Our Ref: EN010122

Application by Oaklands Farm Solar Limited (“the Applicant”) for a non- material change (“NMC”) to the Oaklands Farm Solar Park Order 2025 as corrected by the Oaklands Farm Solar Park (Correction) Order 2025

REQUEST FOR INFORMATION

Works No. 4
Works No. 4a
Works No. 4b
Works No. 6
Works No. 8

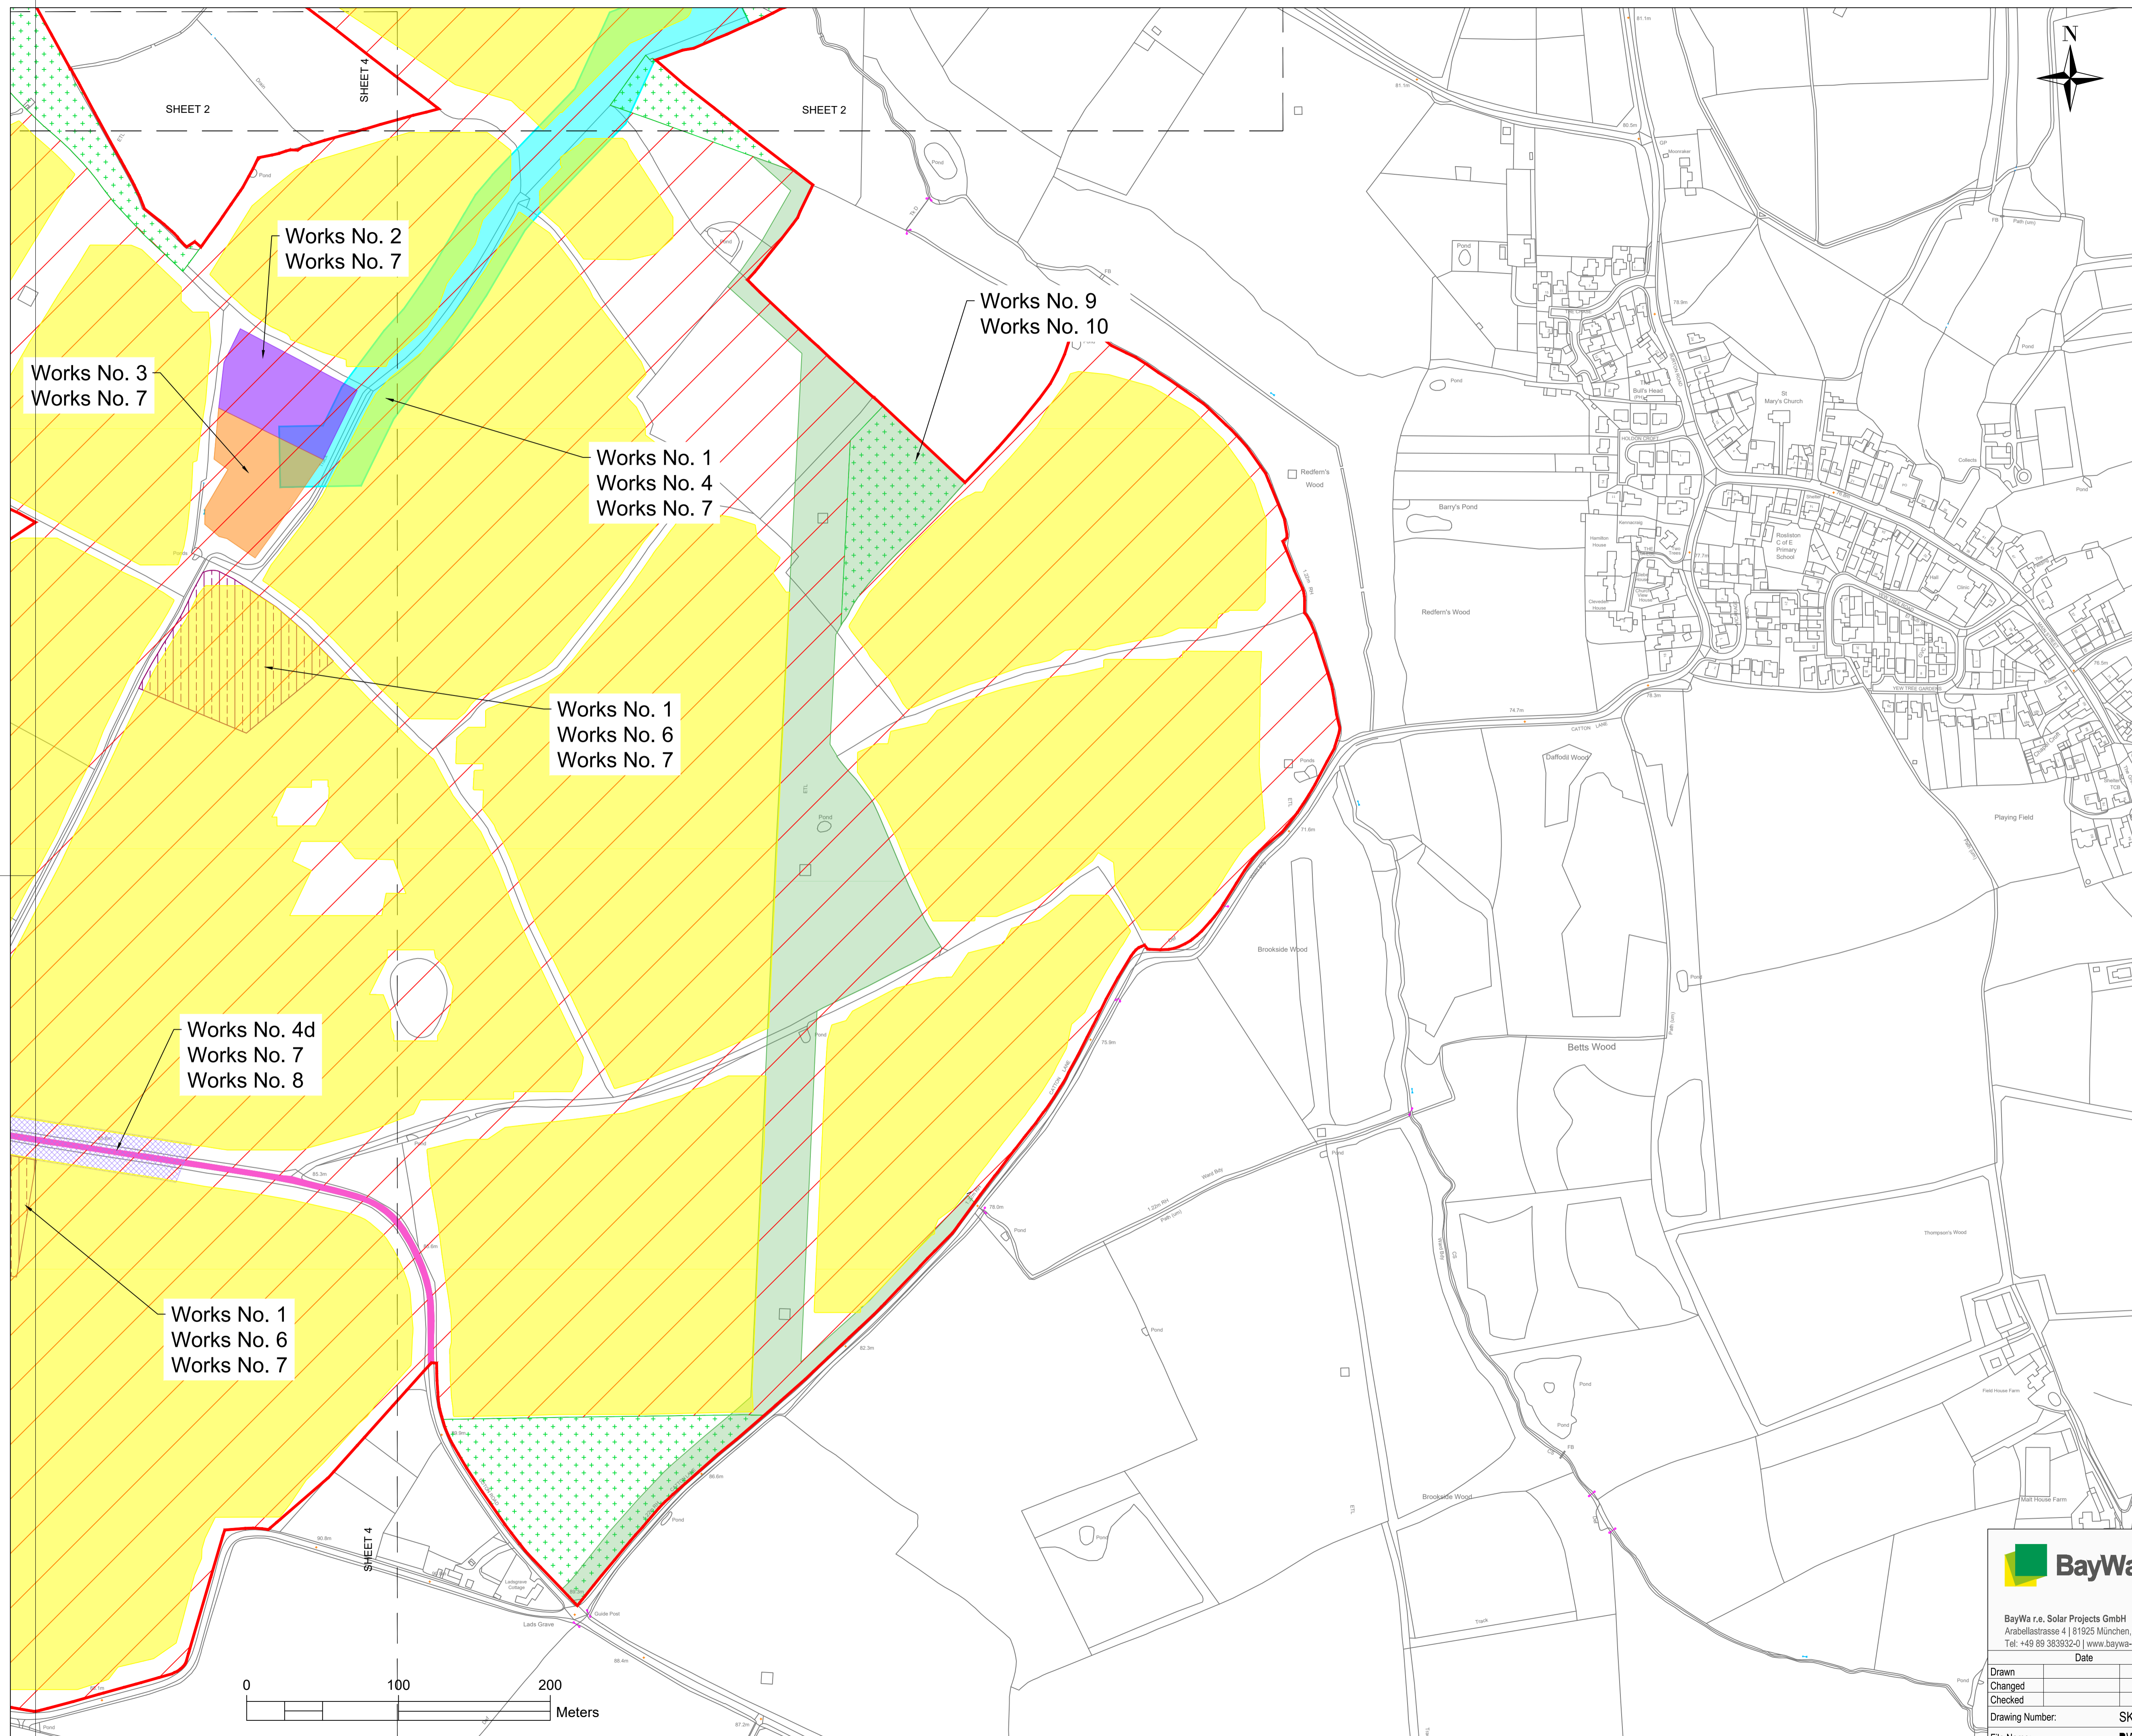
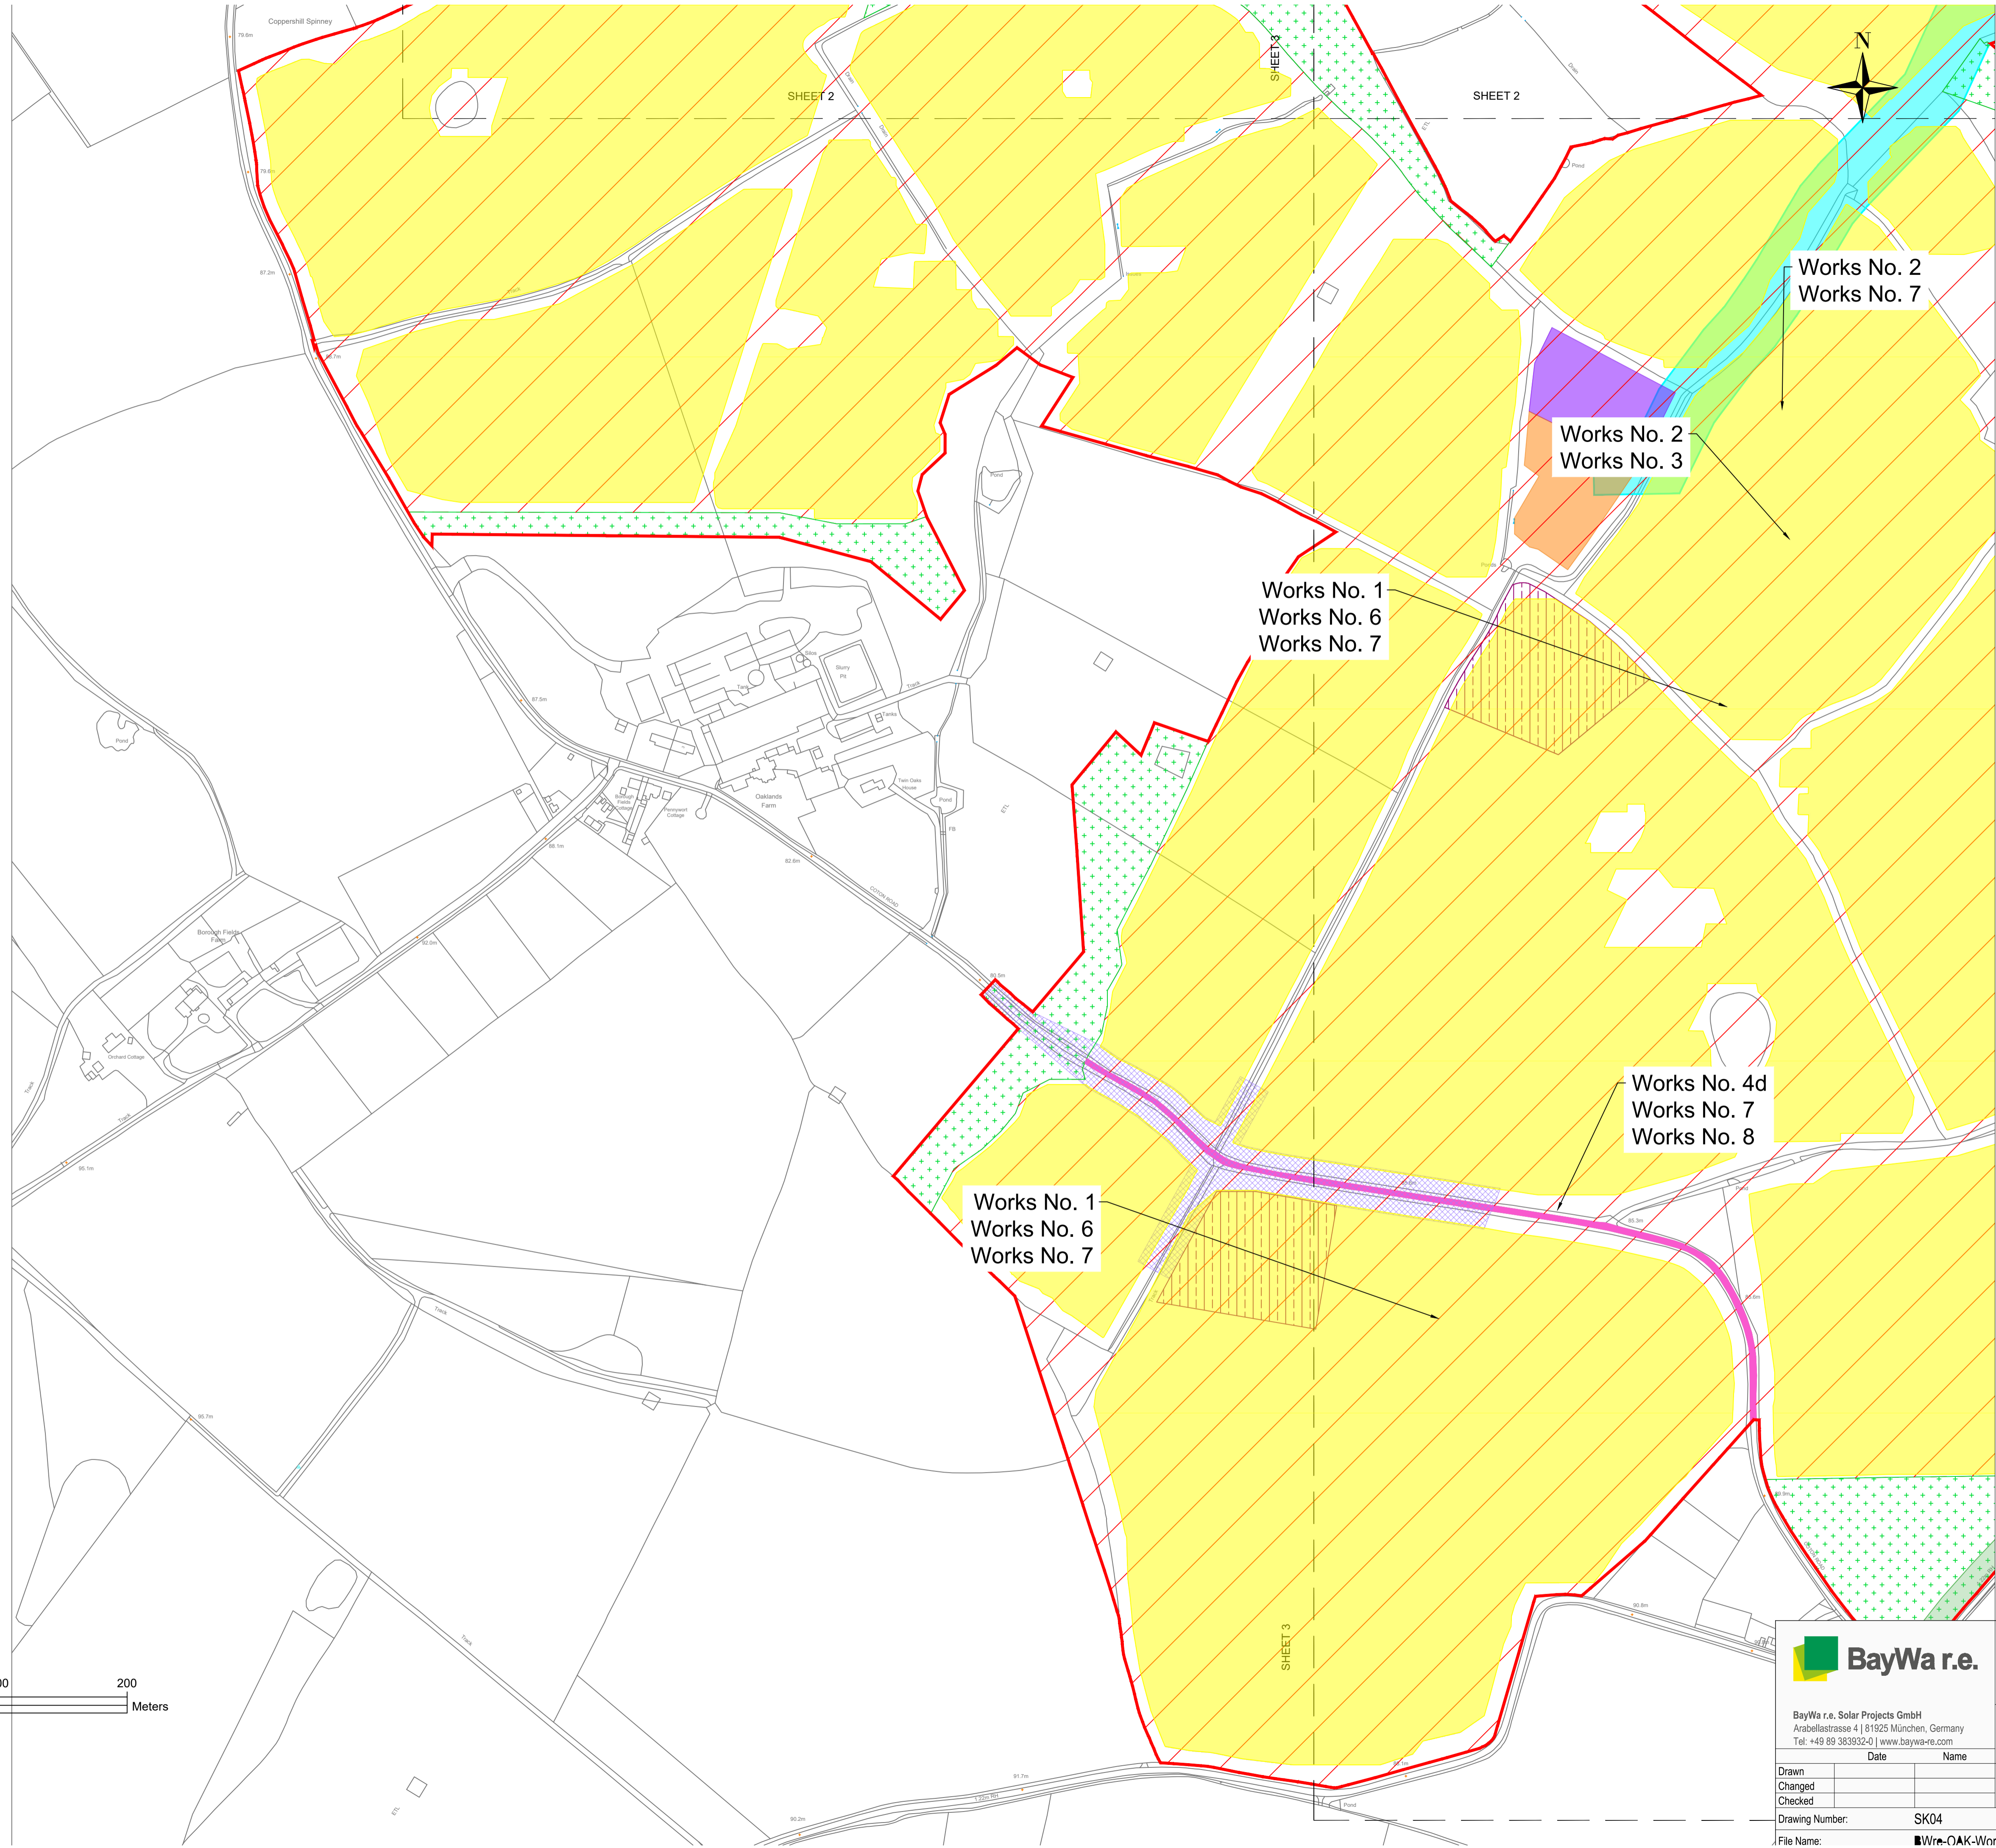
1. The Secretary of State has considered the Application documents, the responses received to the Applicant’s consultation and the reply from the Applicant to the Environment Agency’s consultation response.
2. The Secretary of State notes the revised Works Plan (EN010122/NMC/2.3), revised Environmental Statement - Chapter 4 Project Description (EN010122/D6/6.1) and the revised Appendix I of the Design Statement (EN010122/NMC/7.2) submitted with the Application. There are matters on which the Secretary of State would be grateful if the Applicant and the Environment Agency could provide updates or information as appropriate regarding the changes being proposed and their likely environmental effects.

9. **The Applicant** is requested to comment on whether the proposed amendment of the solar array layout will impact the ability to adhere to the existing 5m hedgerow and the 15m tree root protection zone buffers.
